**Proposed Minto Resource Recovery Facility (Application SSD-5339) at 7 Montore Road,  
Minto - Response to Submissions -**

Thank you for the request for advice from Public Authority Consultation (PAE-29894471), requesting the review by the NSW Environment Protection Authority (EPA) of the Response to Submissions for the proposed Minto Resource Recovery Facility (Application SSD-5339) at 7 Montore Road, Minto.

Figure 3: Site layout plan.

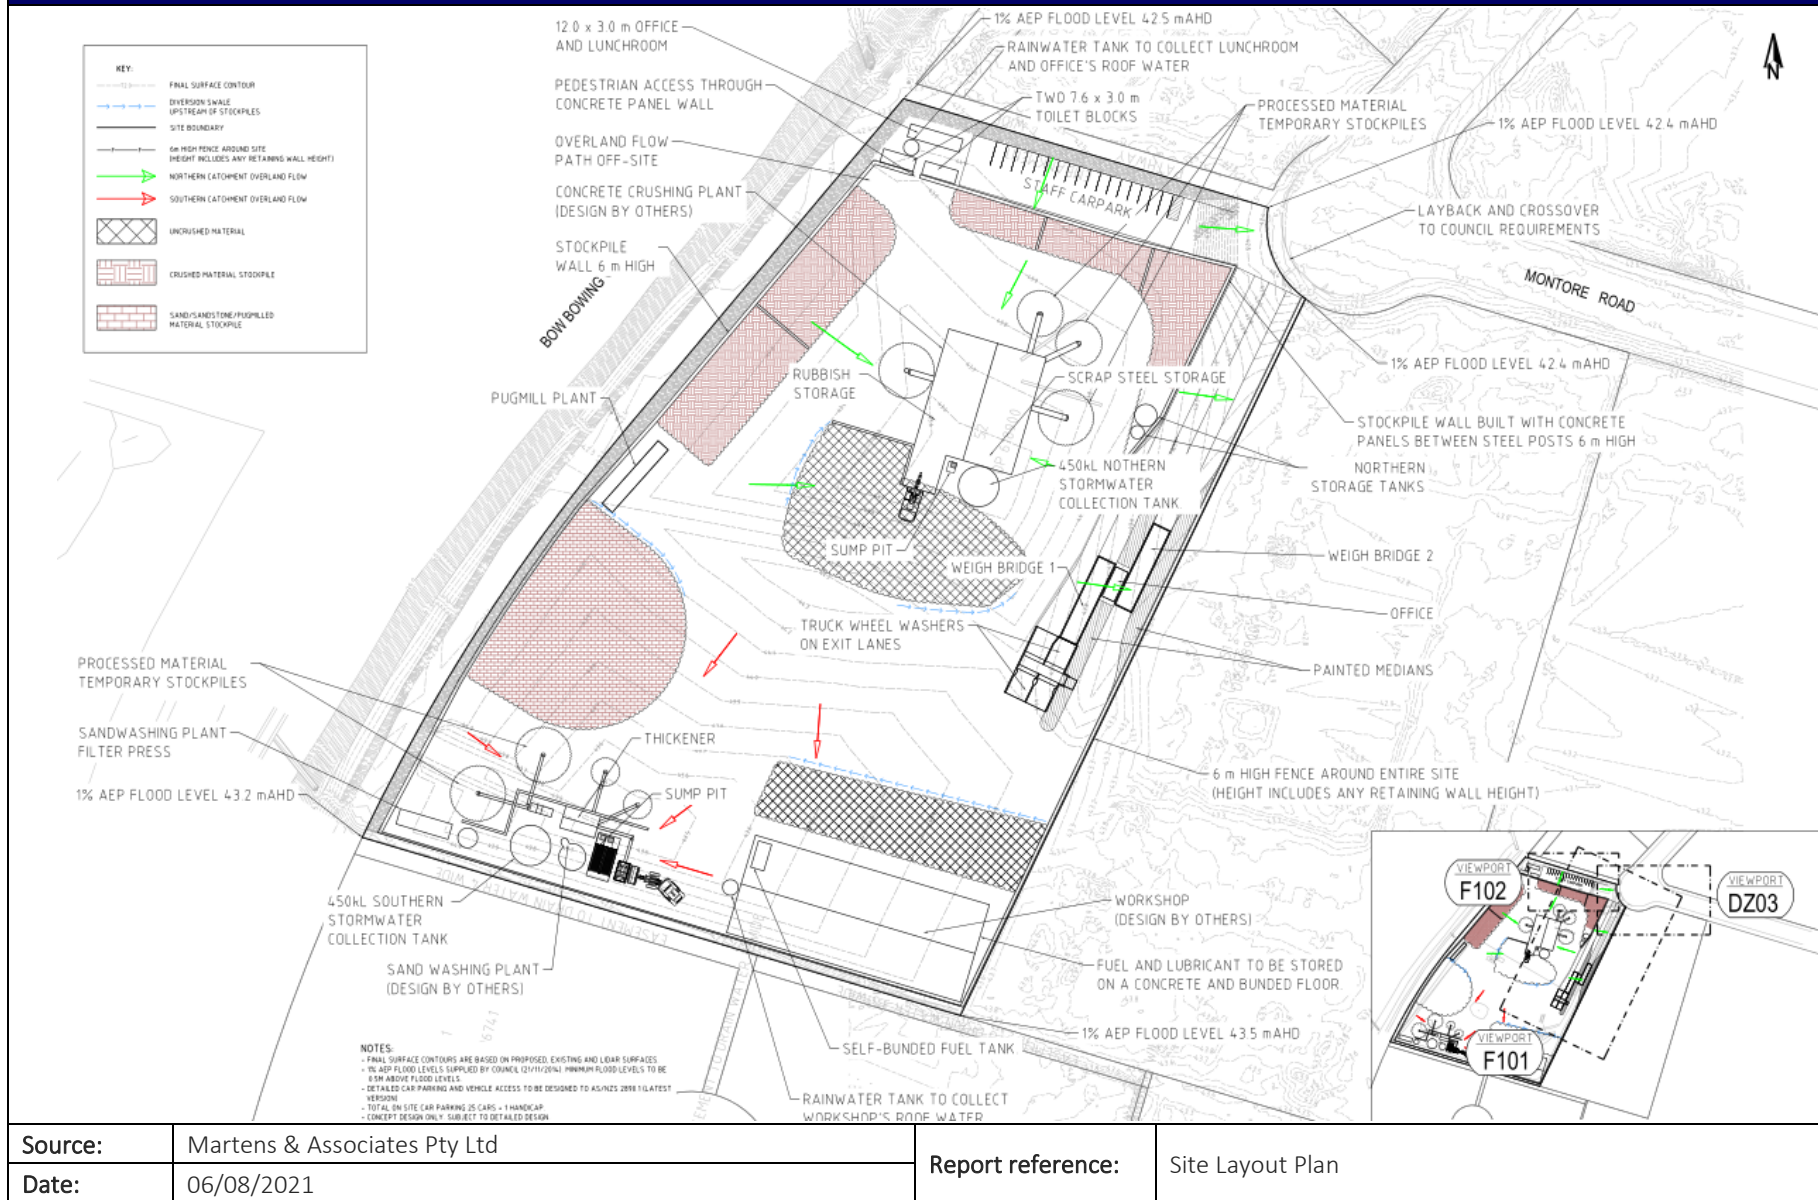
The applicant has now provided updated site plans that include stockpile sizes and locations. The plans however still do not include designated tip-and-spread areas as required by the Standards and discussed above. The Standards set the requirements for such tip-and-spread areas at construction and demolition waste facilities including their size and composition and set signage requirements for stored waste. If approval for the proposal is granted and a licence issued for the facility, the licensee will be required to comply with the Standards at all times.
